From: Contact Centre (CRM) <contact@ribblevalley.gov.uk>
Sent: 03 May 2024 17:13
To: Planning
Subject: Planning Application Comments - 3/2024/0183 FS-Case-611535035

Planning Application Reference No.: 3/2024/0183

Address of Development: 6 The Dales
Langho BB6 8BW

Existing Site Plan

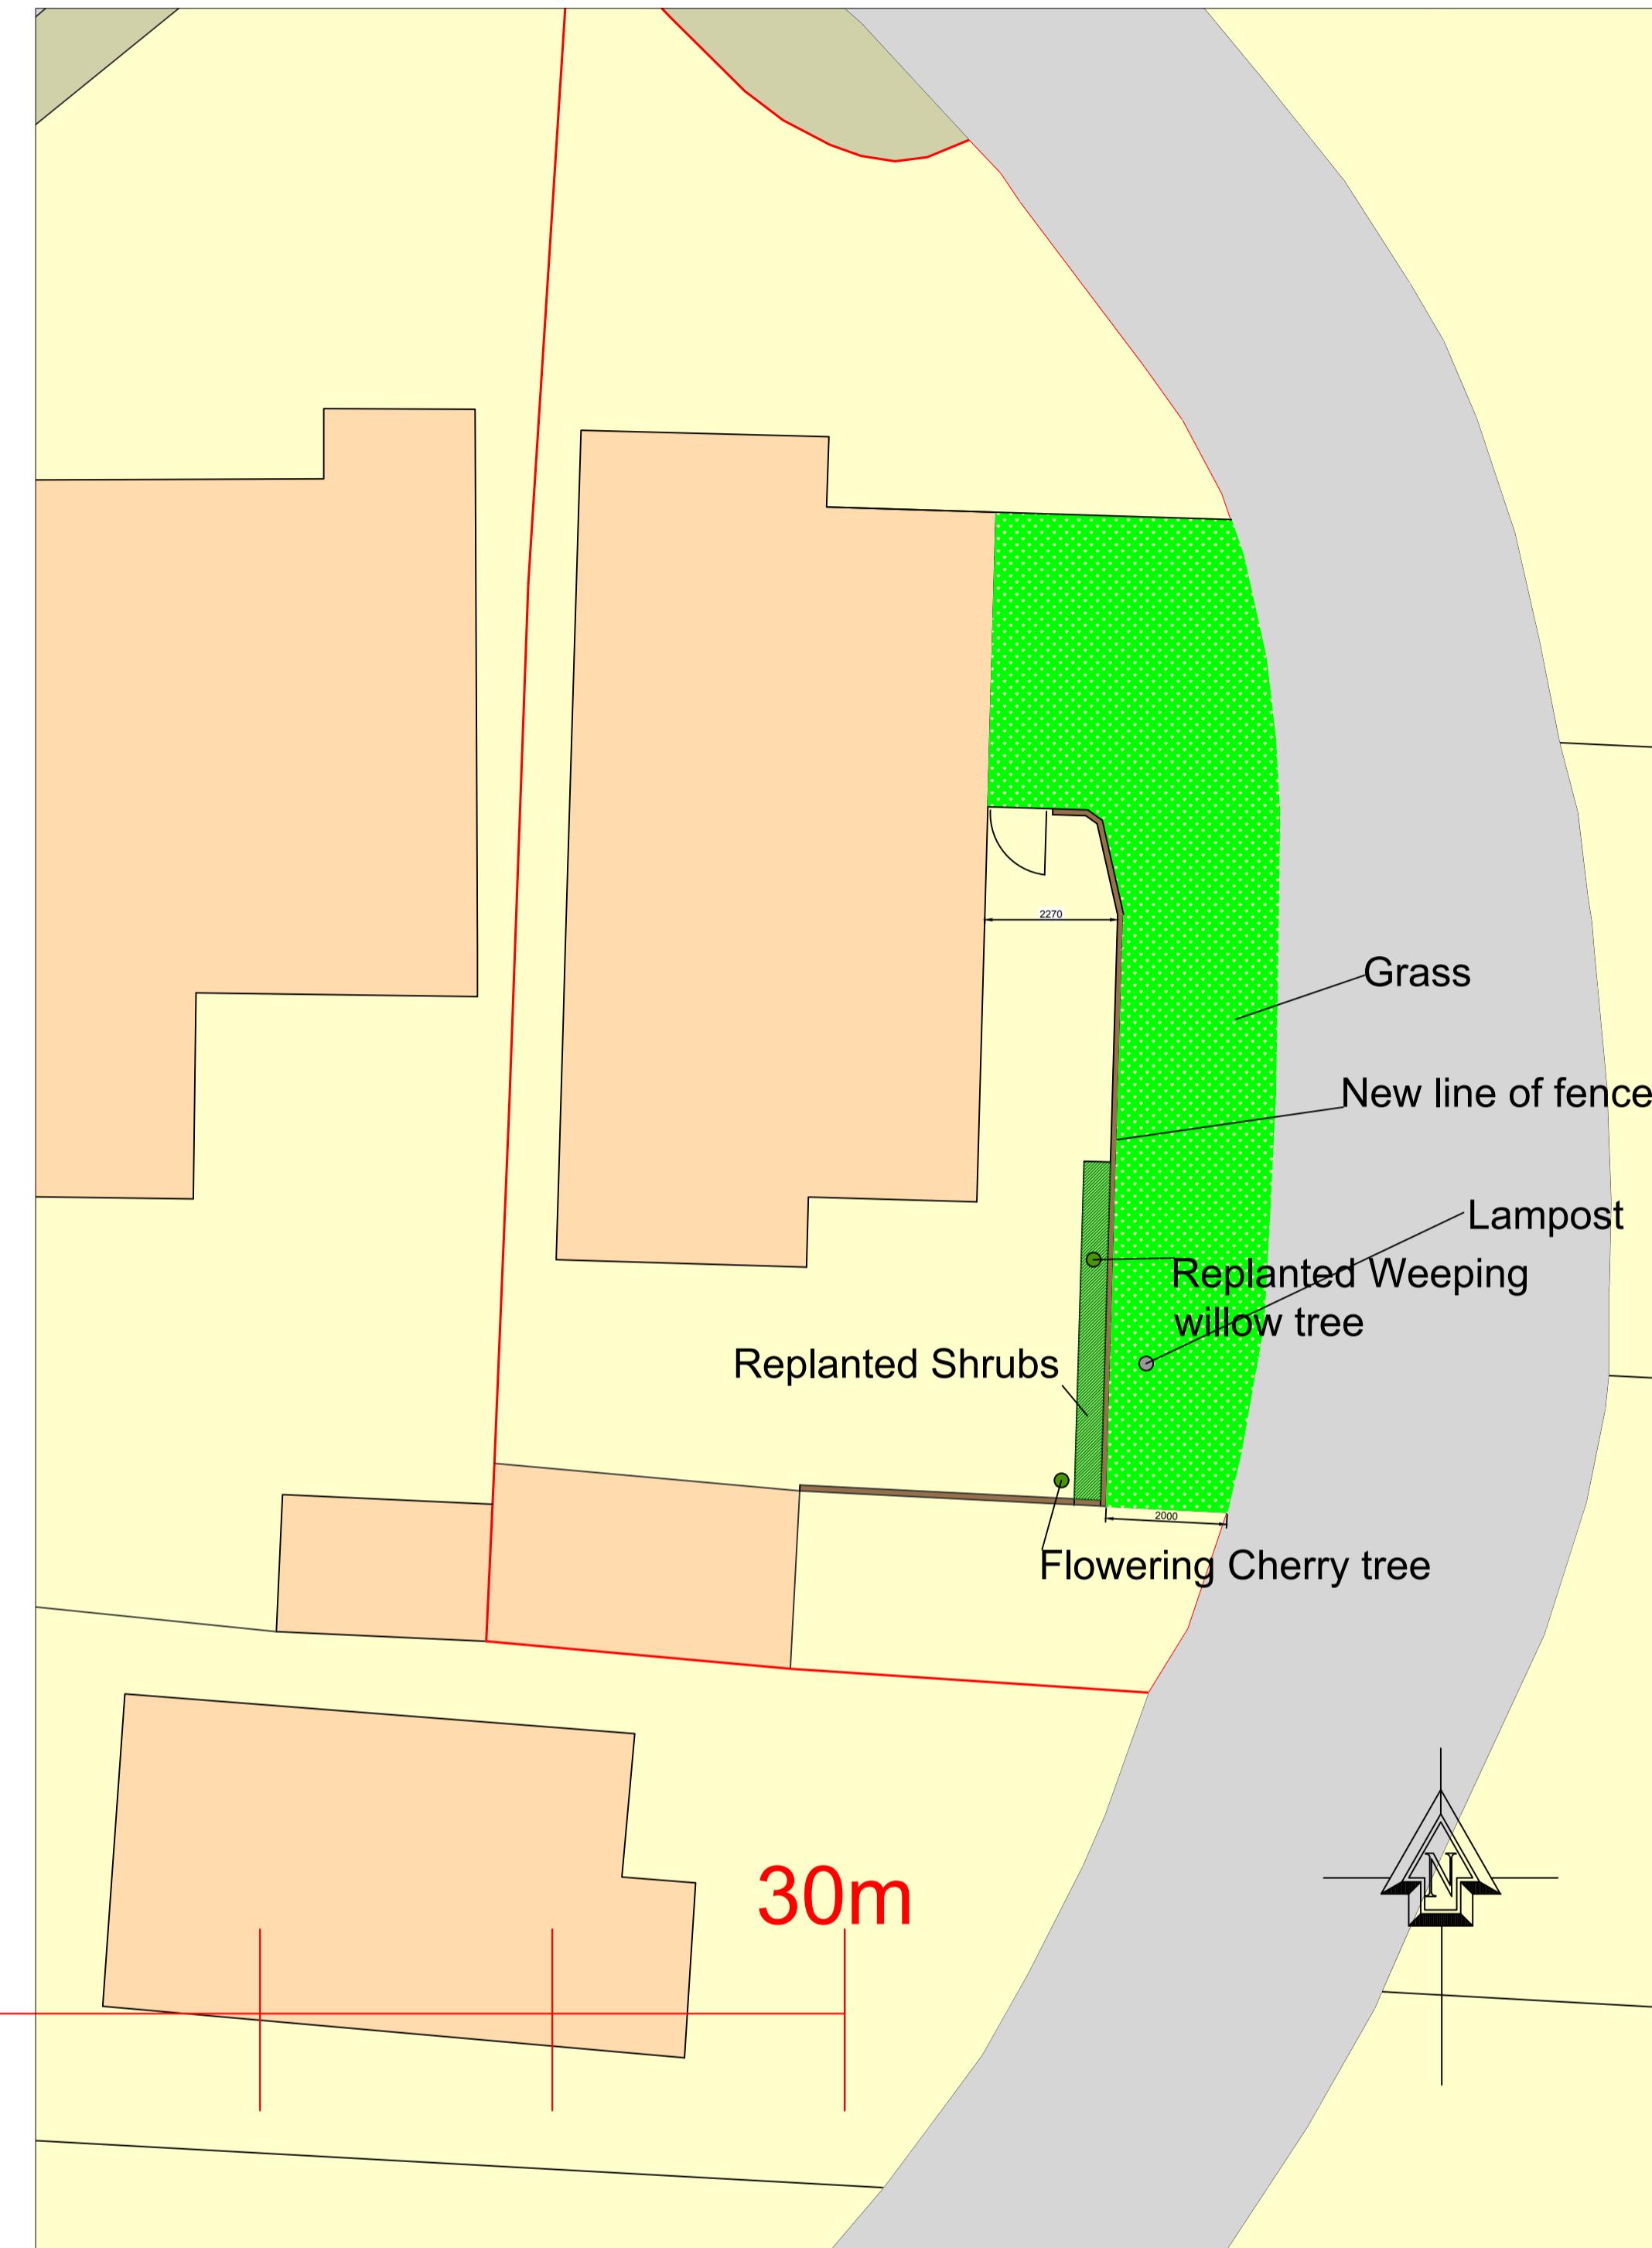
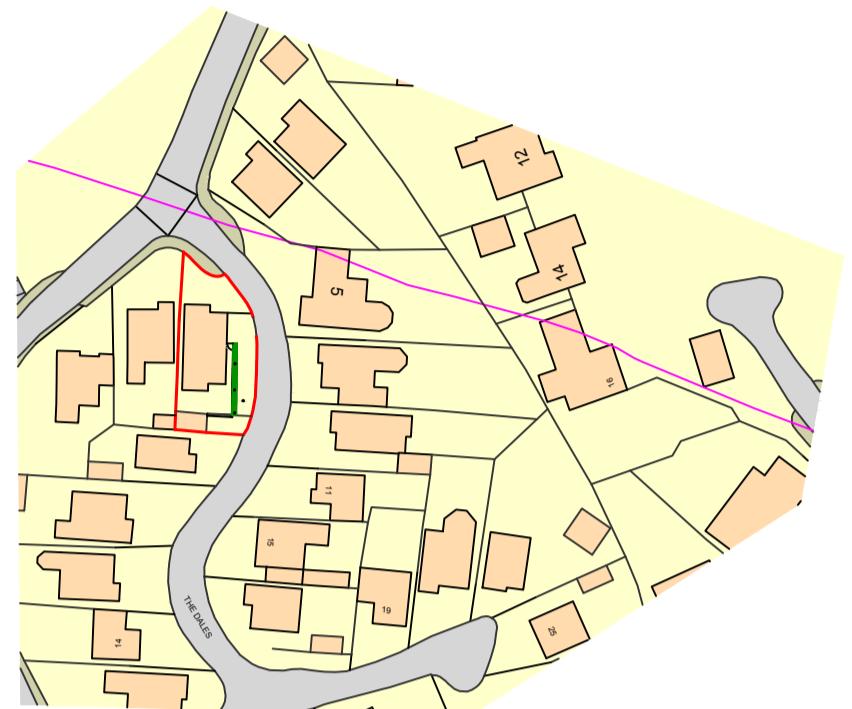
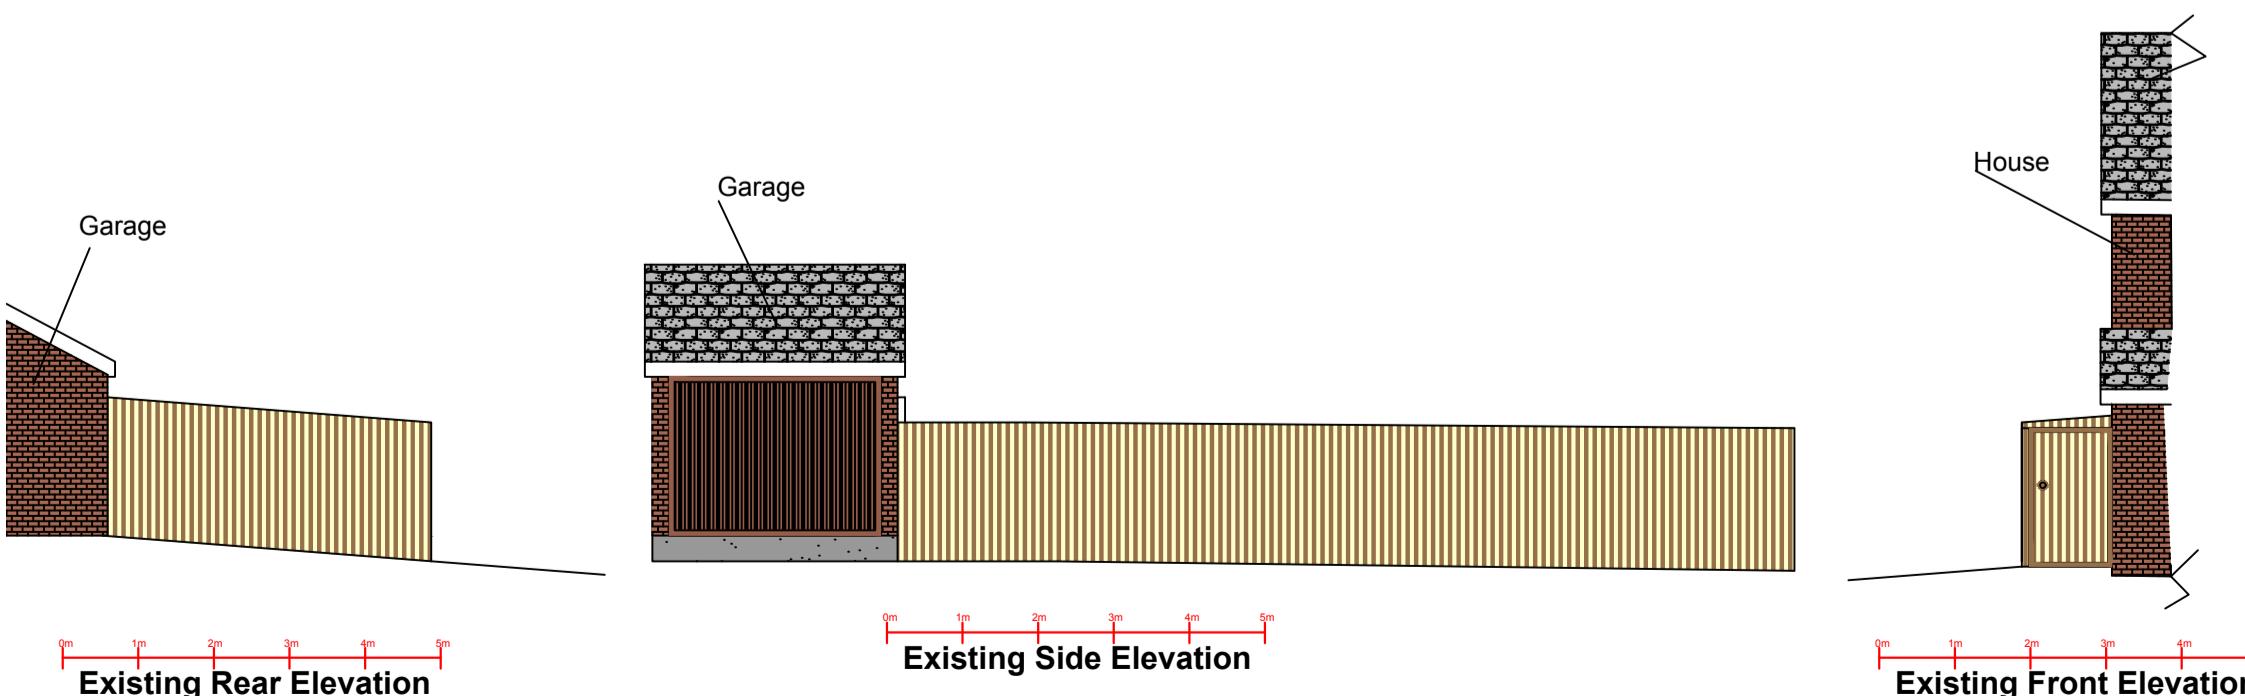
Comments: The revised planning application drawings do not show the 3 trees currently on the site either on the existing site plan or the proposed site plan. It is our understanding from discussions with the applicant that 2 of the 3 trees would be retained. Why are the 3 trees not shown on the existing site plan? We therefore object to the amended planning application on the basis that we do not want these trees felling.
